Marist Catholic College North Shore (SSD-10473)
Response to Submissions

ATTACHMENT 1

LEGEND:

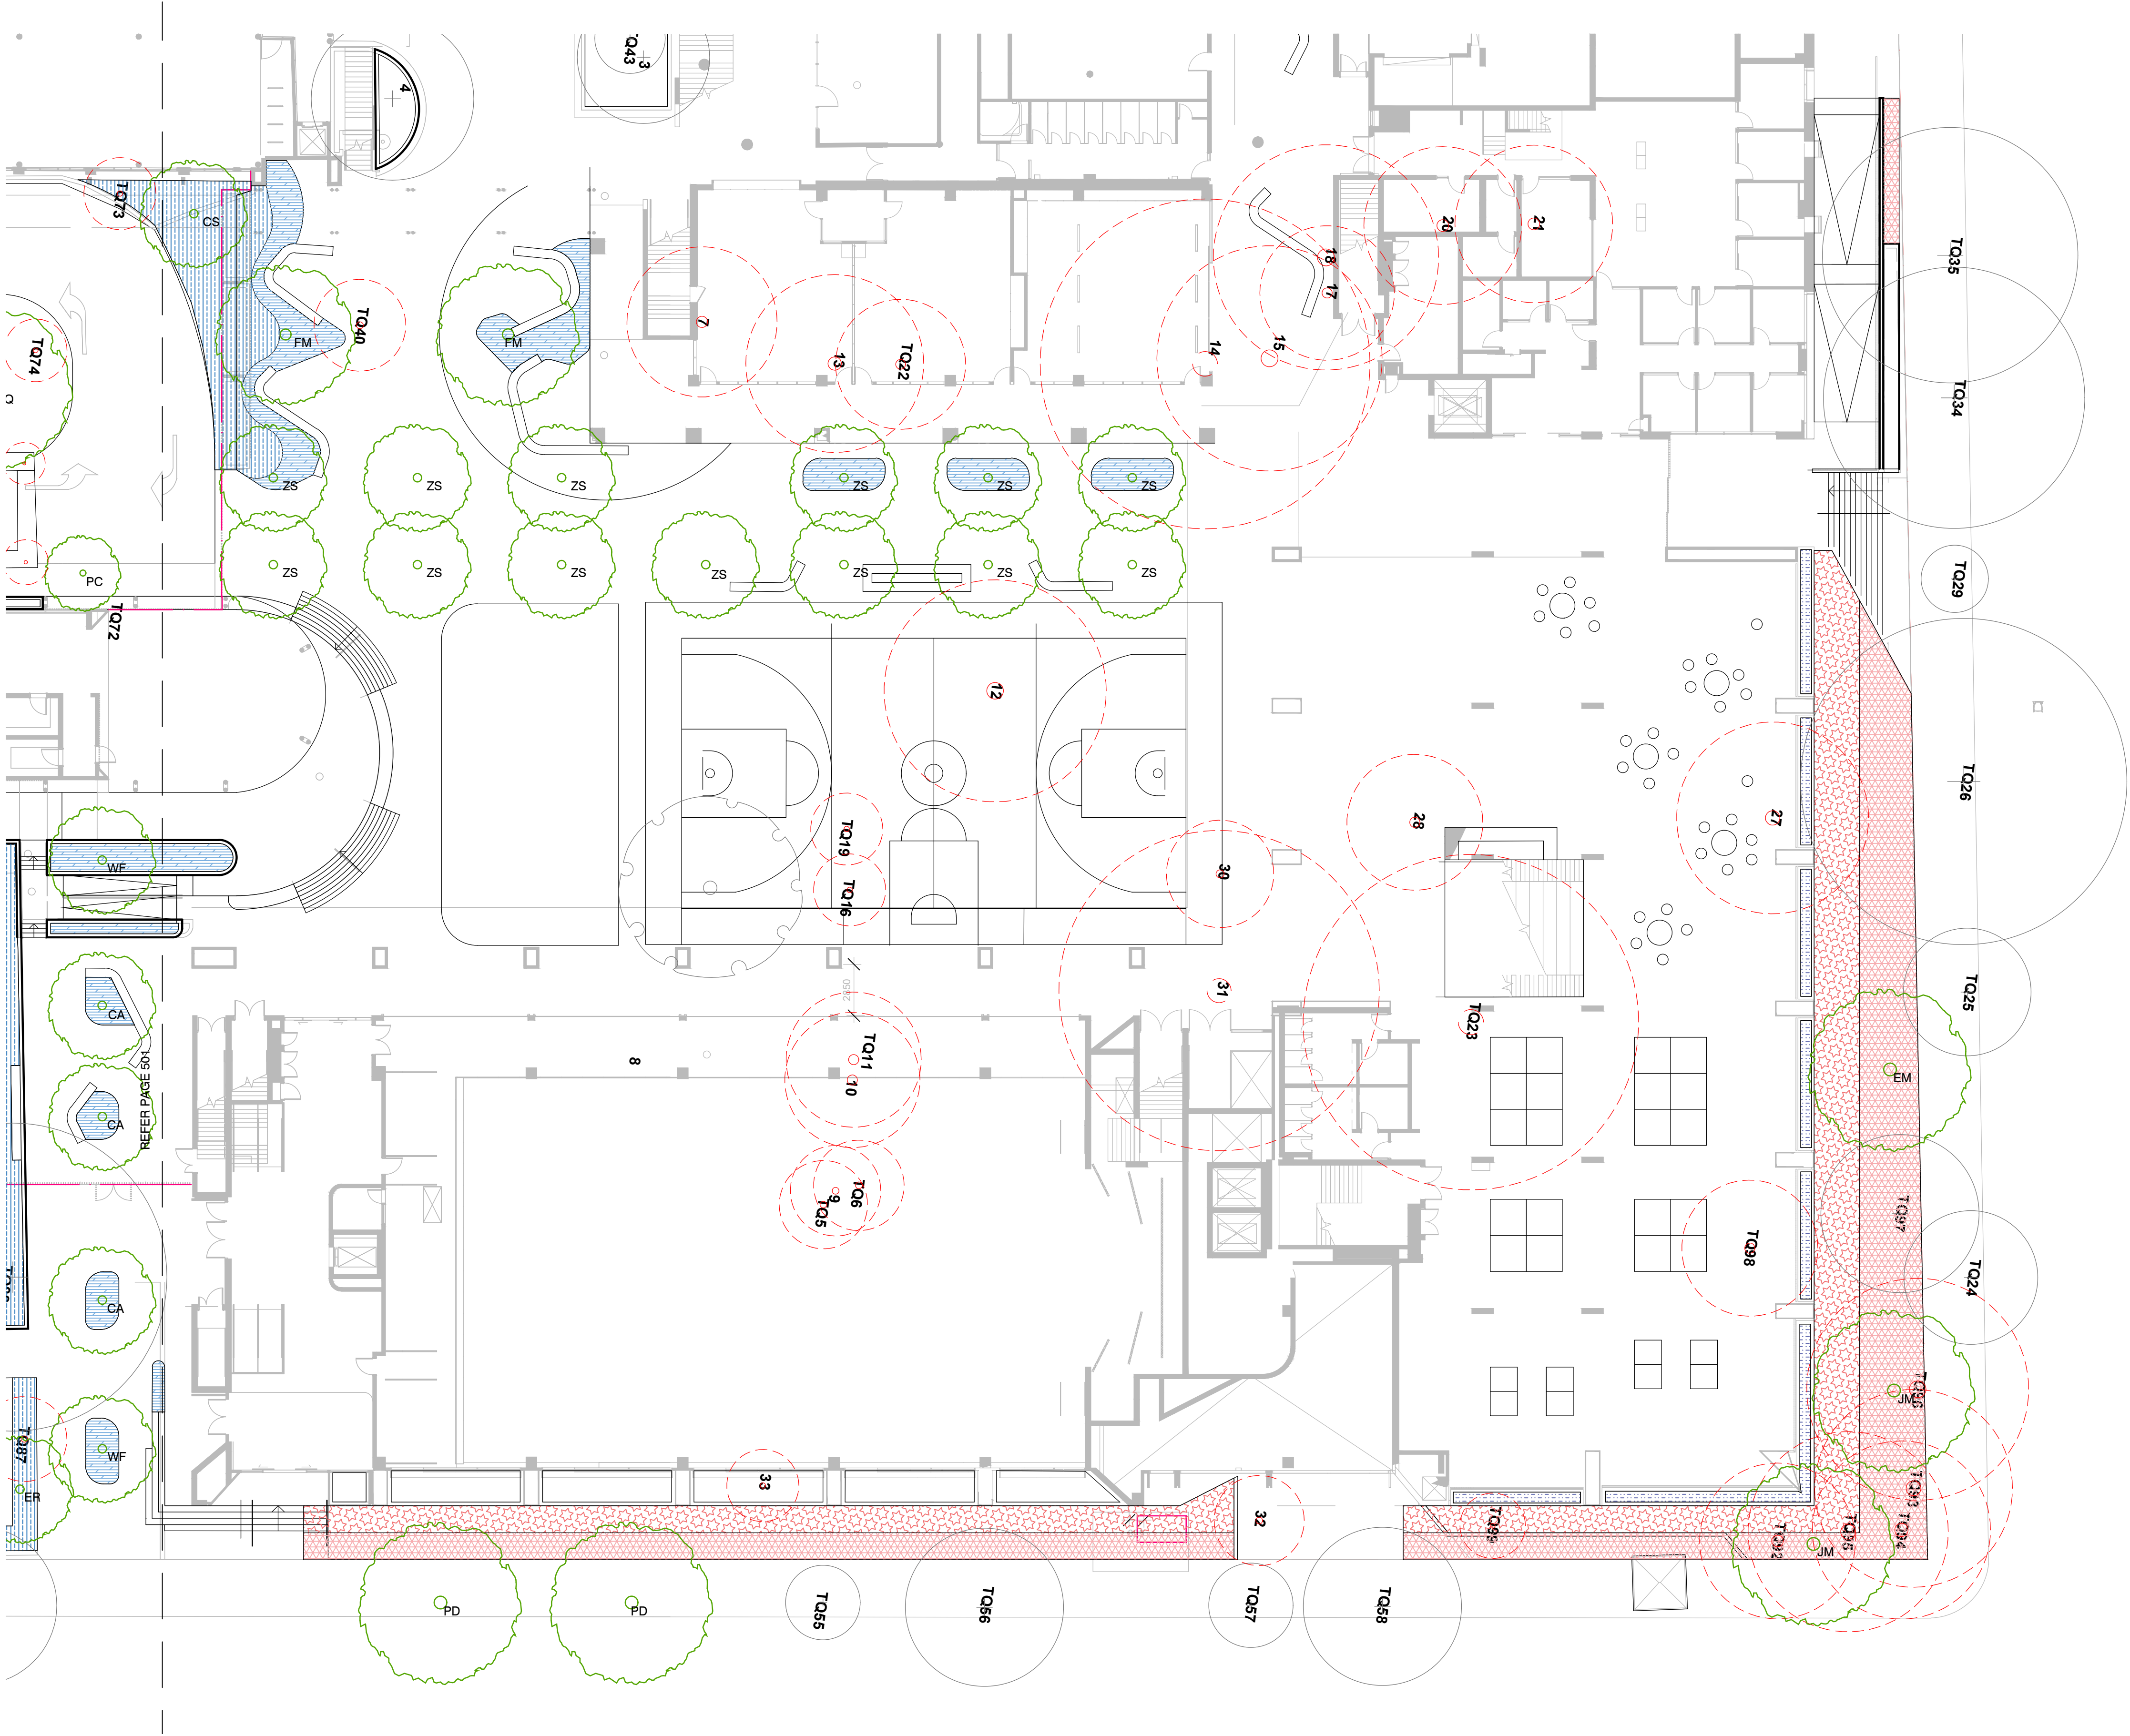
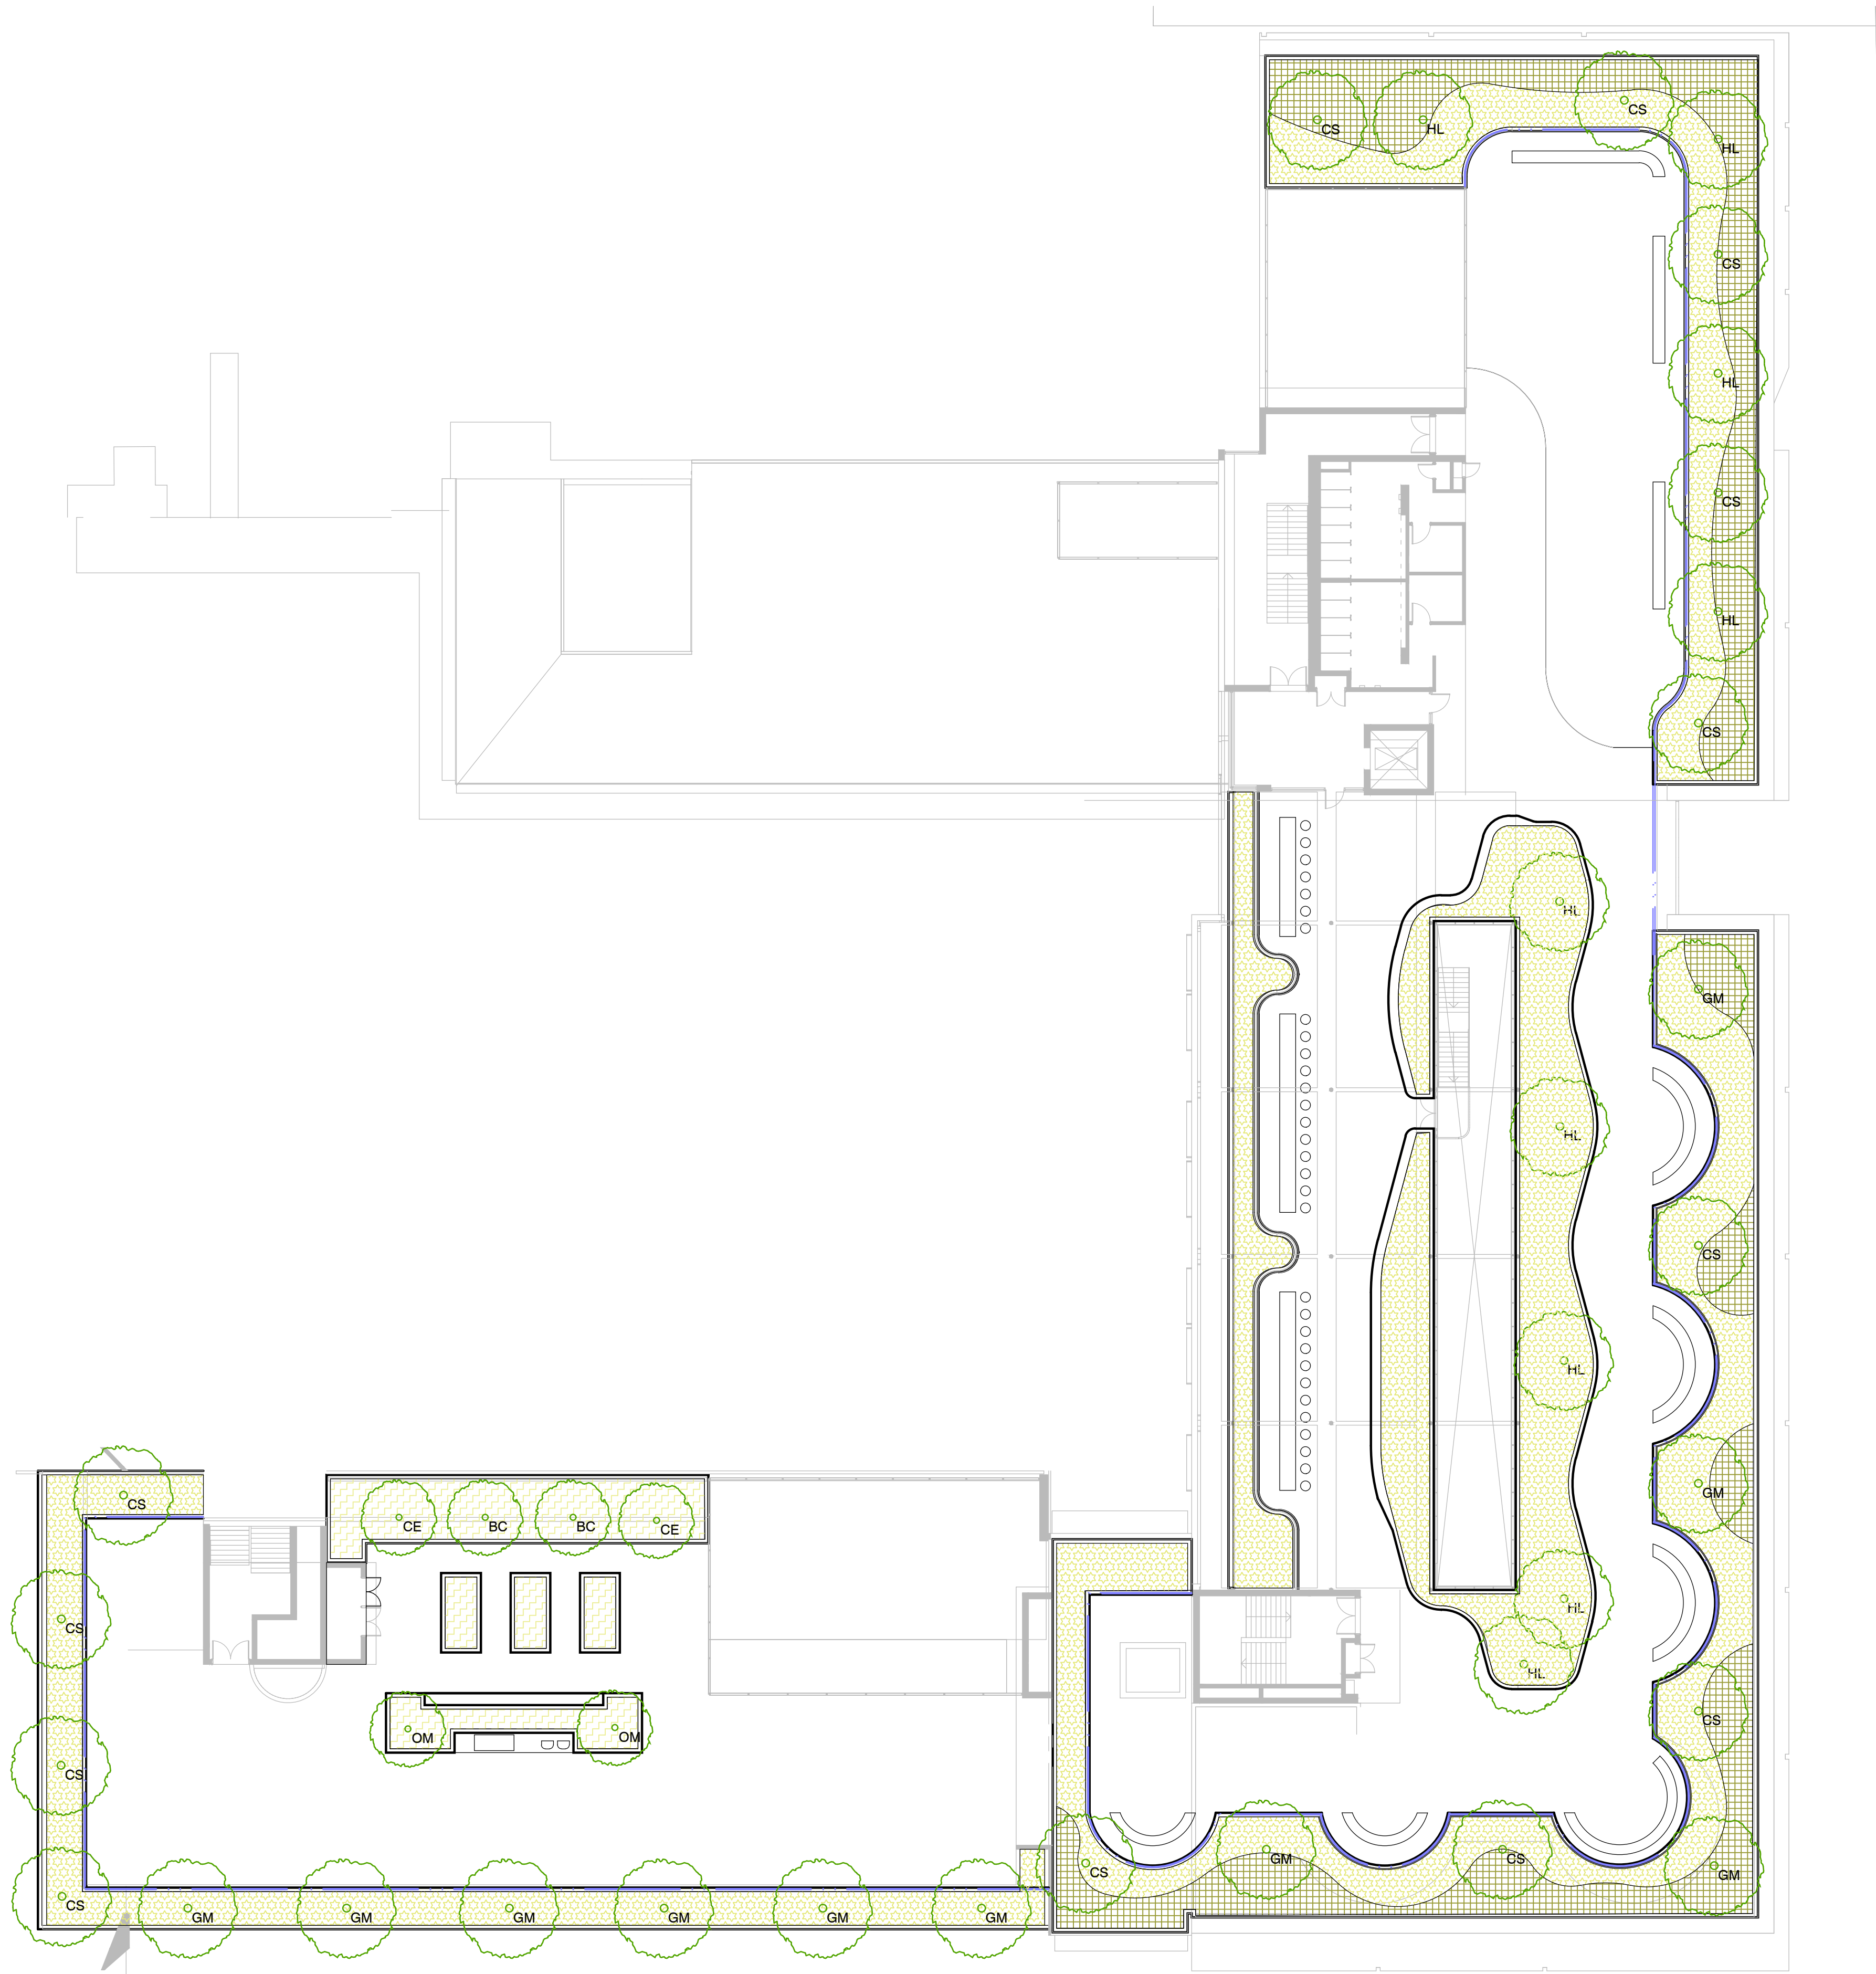
- A revised Landscape Plan that provides exact details of planting locations, species, quantities and pot size is to be submitted in the architectural drawing package.
